September 18, 2018

**RE: Legacy Uptown Apartments
Grading and Drainage Plan
Engineer's Stamp Date: 09/05/18
Hydrology File: J18D033**

Based upon the information provided in your submittal received 09/06/18, the Grading and Drainage Plan **is not** approved for action by the DRB for Site Plan for Building Permit. The following comments need to be addressed for approval of the above referenced project:

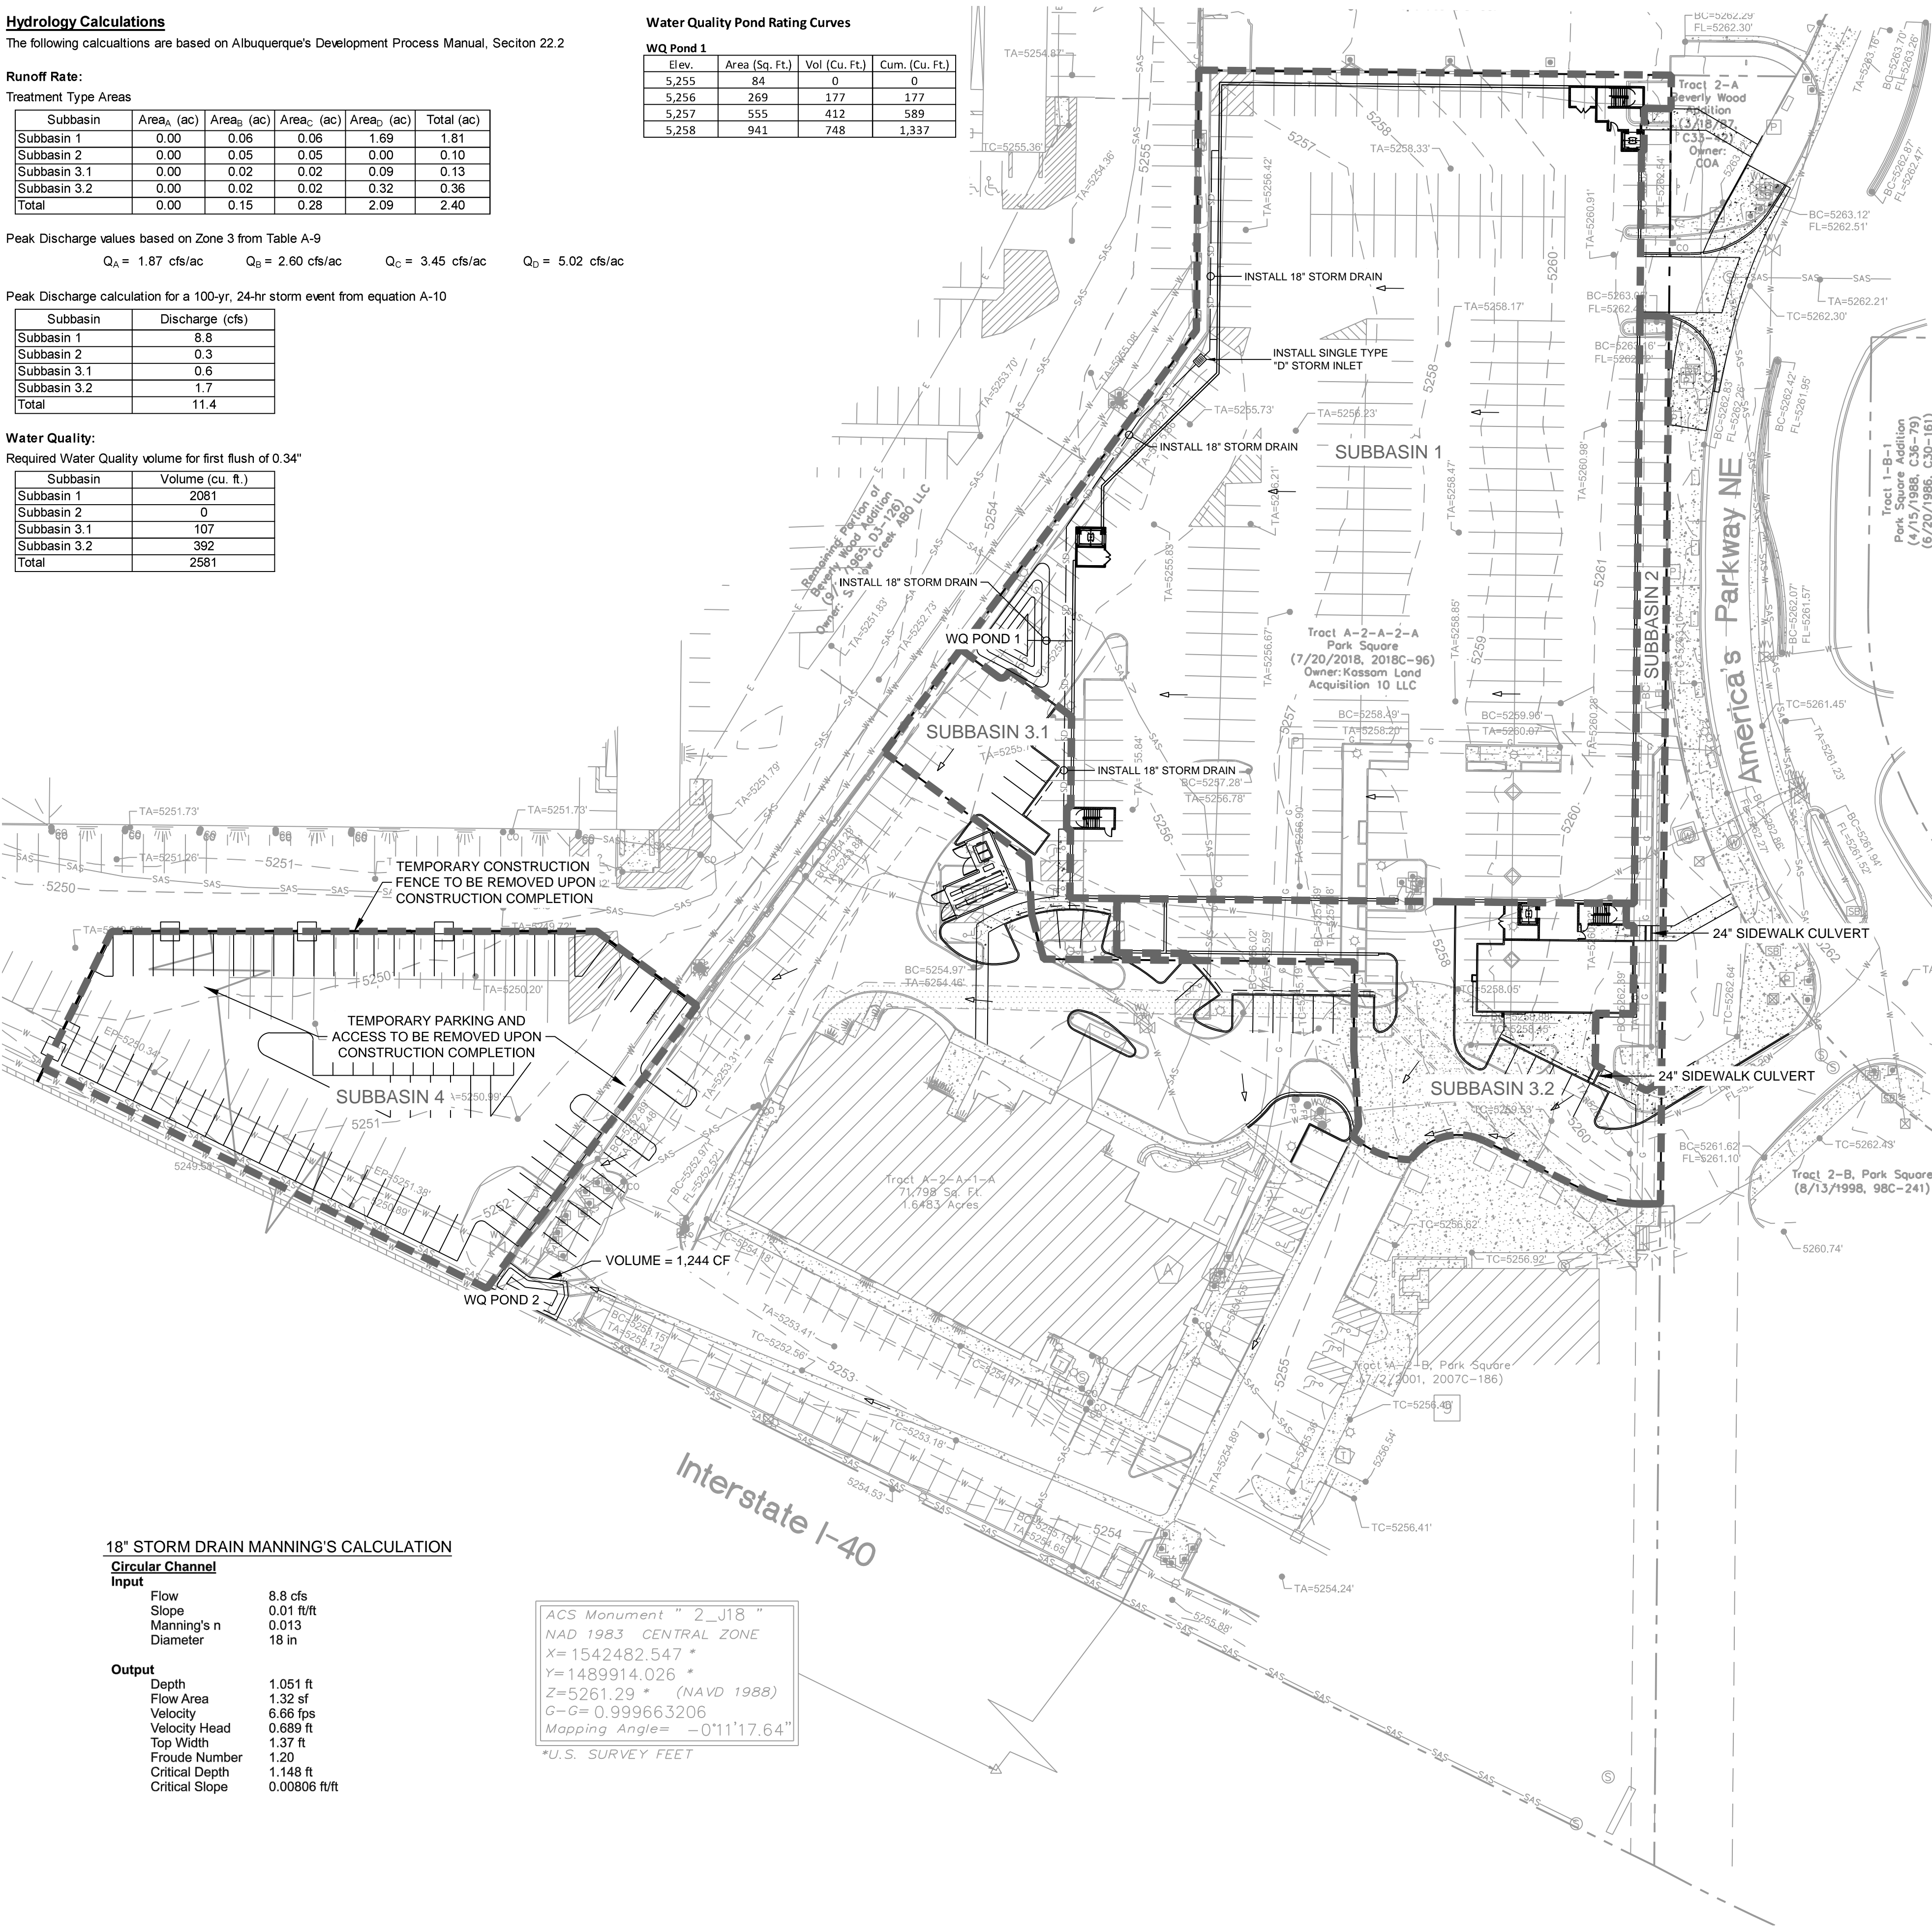
1. Please provide the benchmark information for the survey contour information provided.
2. Please add the effective date of the FIRM Map.
3. Please label the other sidewalk culvert on Sheet C-1.
4. Please label the construction fence and the temporary parking on the adjacent apartment property Sheet C-1.
5. Please make the off-site temporary parking as a separate basin on Sheet C-1. Please state that the area will be restored to pre-construction conditions if that is what is going to be done. If this will not happen, then a first flush pond for the newly added parking area will need to be identified.
6. For Sheet C-2 only, please remove the existing survey information that will be demolished and replaced by this project. Also please provide a light hatch pattern for the proposed sidewalk. This will help in the review process to determine what is being proposed and what is staying.
